CITY OF ALBUQUERQUE

**Re: Tract B, Airport Technical Center Grading and Drainage Plan
Engineer's Stamp dated 2-25-08 (N15-D1A3A)**

Re: Tract B, Airport Technical Center Grading and Drainage Plan
Engineer's Stamp dated 12-11-07 (N15-D1A3A)

**RE: Grading and Drainage Plan for Tract B Airport Center,
N-15/D001A3A**

C-101

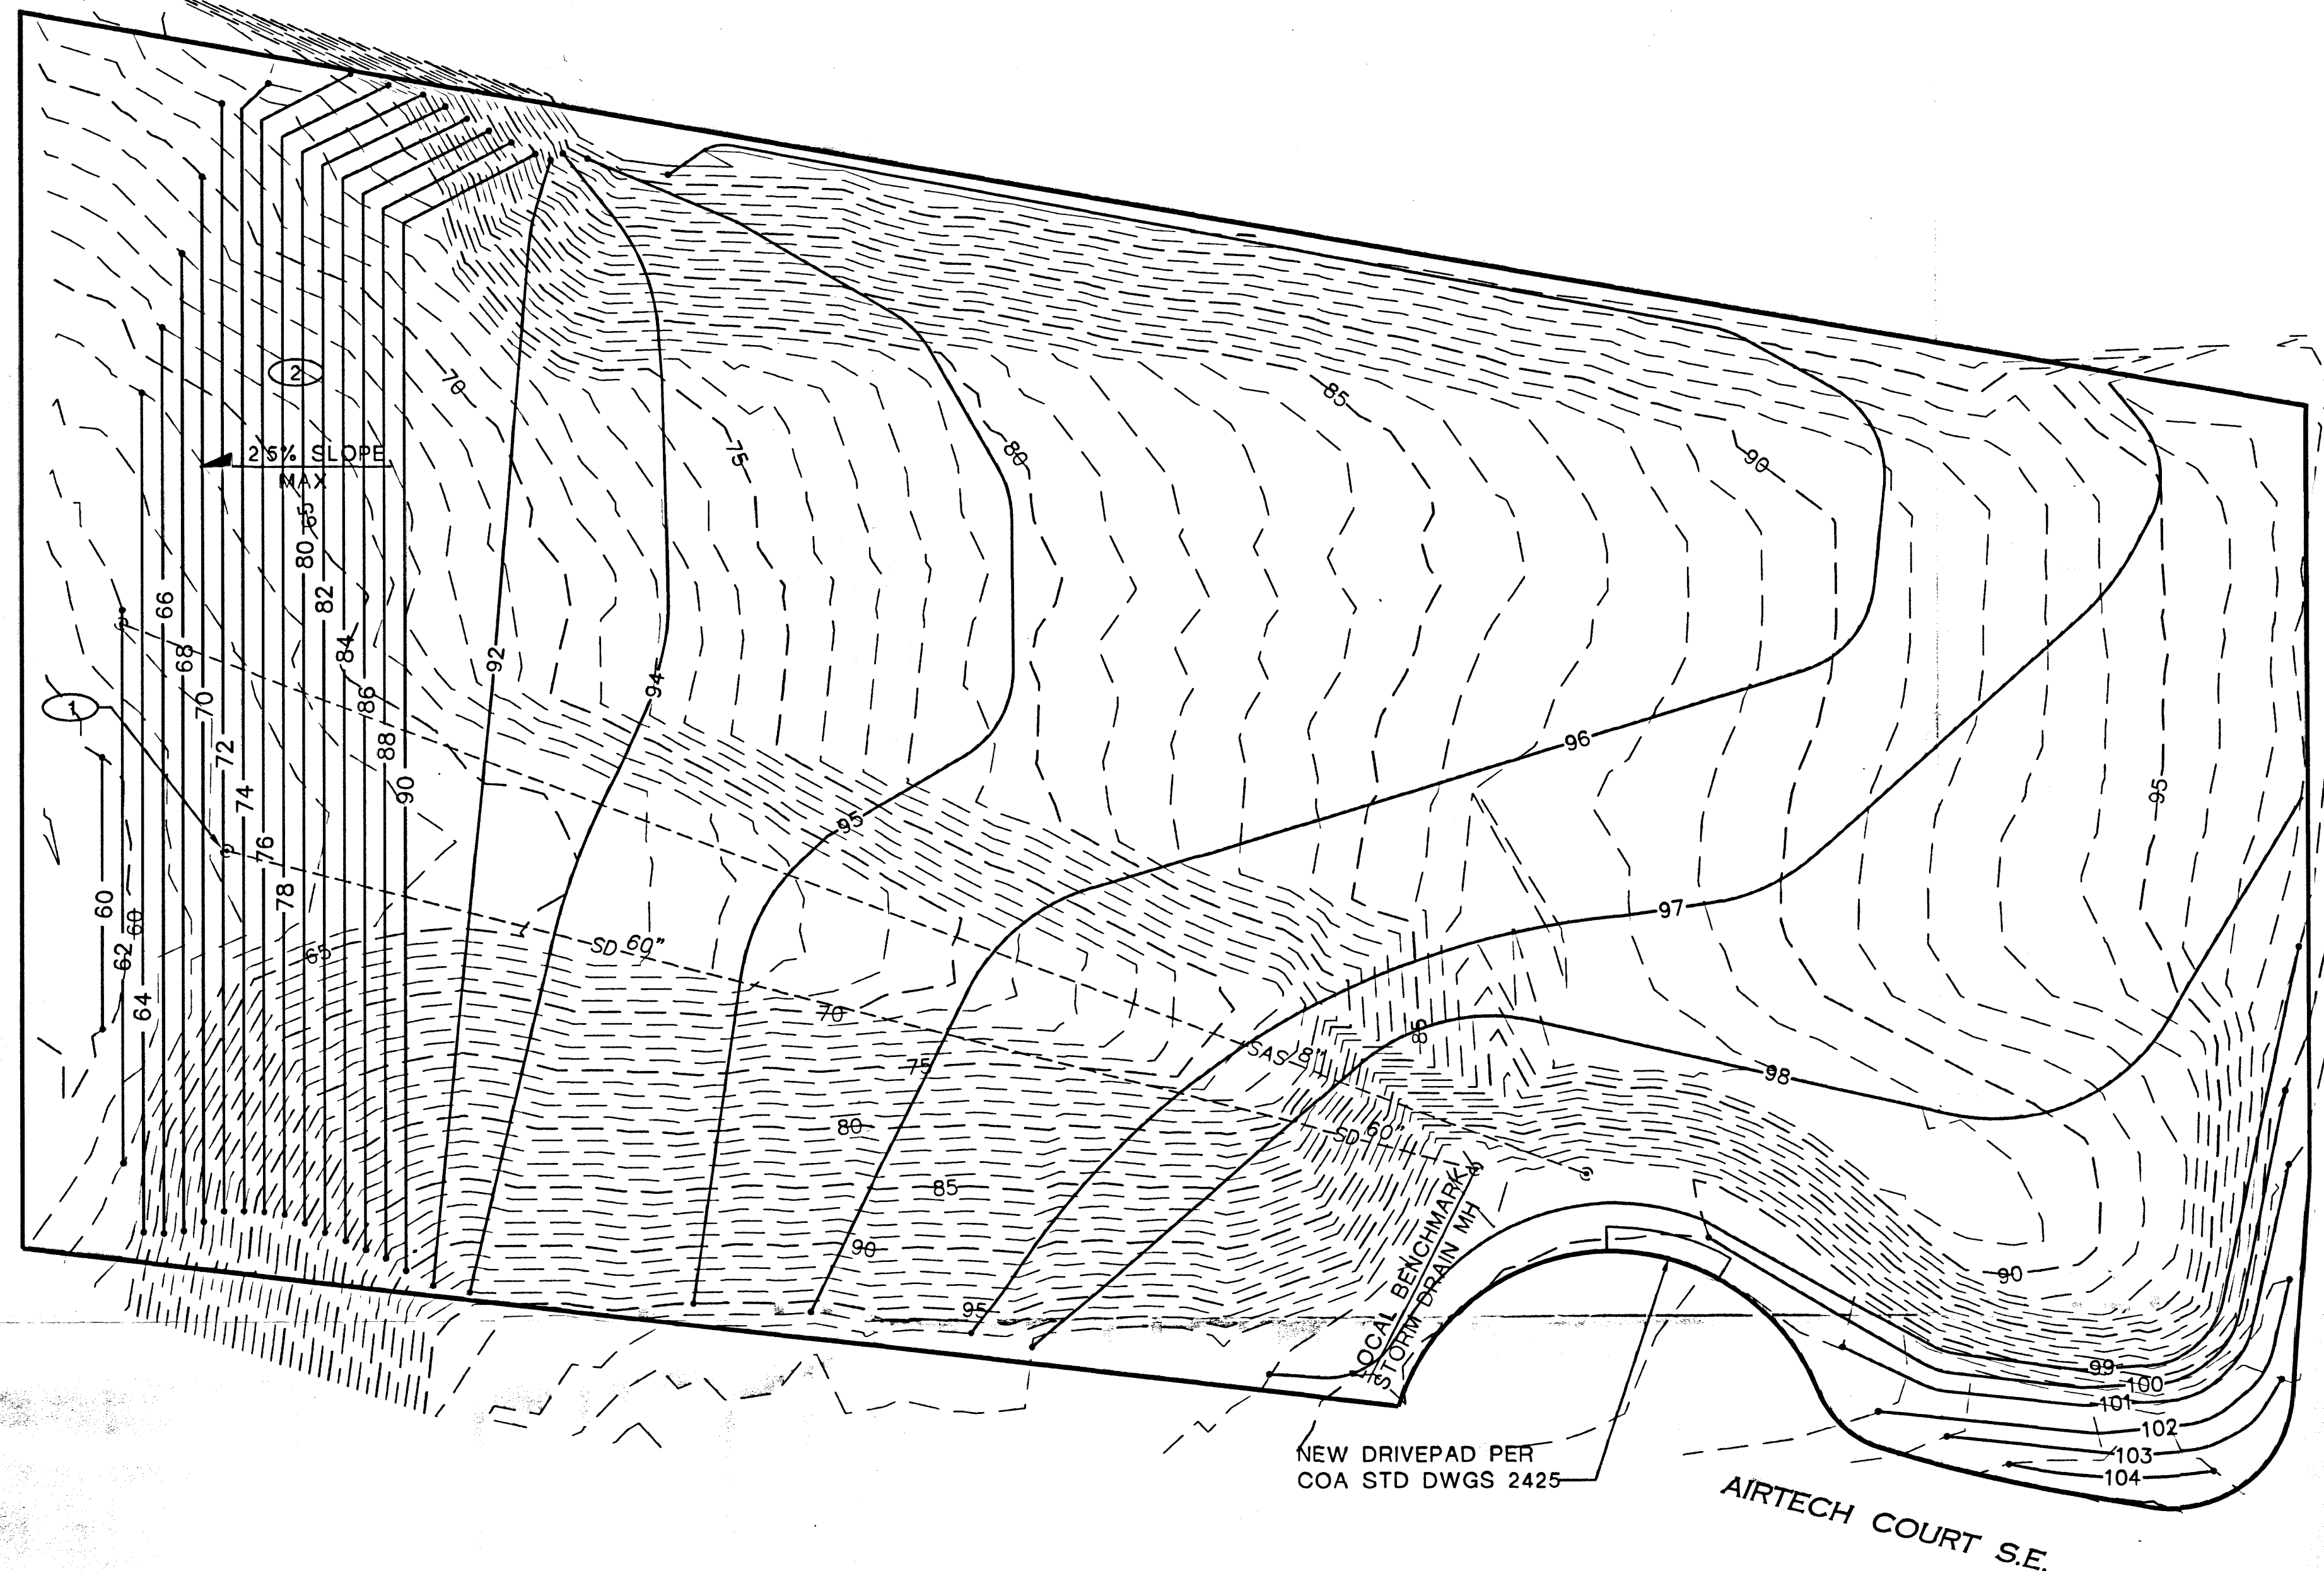
- Your grading plan shows runoff draining to the properties to the south, north and east. I prefer to see that Basin A be 2 feet below these properties to make sure that no runoff leaves to any of those properties.
- Where is the access to the site proposed? I will require a new drivepad in order to keep the curb from being broken.
- The slope in Basin B will need some erosion control. There is less runoff but there will be more sediment with the steeper slope proposed.

- The site historically accepted flows from the north and south properties, please describe how these flows will be diverted.
- Please extend the map to show contours showing the surrounding topography. It is not apparent how offsite topography directs flows.

- The plan appears to increase drainage directed away from the site to the North, South and East properties, please address these flows. The original site grading was designed to capture nearly all the water from this area that would otherwise drain to the UNM Golf Course. It appears in contradiction to the submitted plan that by extending the slope the flows to the golf course will increase.

- Please provide calculations showing that the existing infrastructure can support the addition of up to approximately 35' of soil. It is unlikely that the existing storm drain or sanitary sewer will support this fill.

- The plan does not show how water will enter the storm drain system within University Blvd.
- The proposed slope shows "2.5% Max" that does not appear to be reflective of the drawing.

- Please include additional information on the erosion protection and any seeding requirements.
- There appears to be an area of concentrated flows at the North portion of Tract B. Please describe the erosion protection that shall be used on the slope.

- Please show all City infrastructure on the plan. The full length, junctions, and all manholes do not appear to be shown. The adjustment of manholes may require the placement of an interior landing at the midpoint. Please show this on the plan.
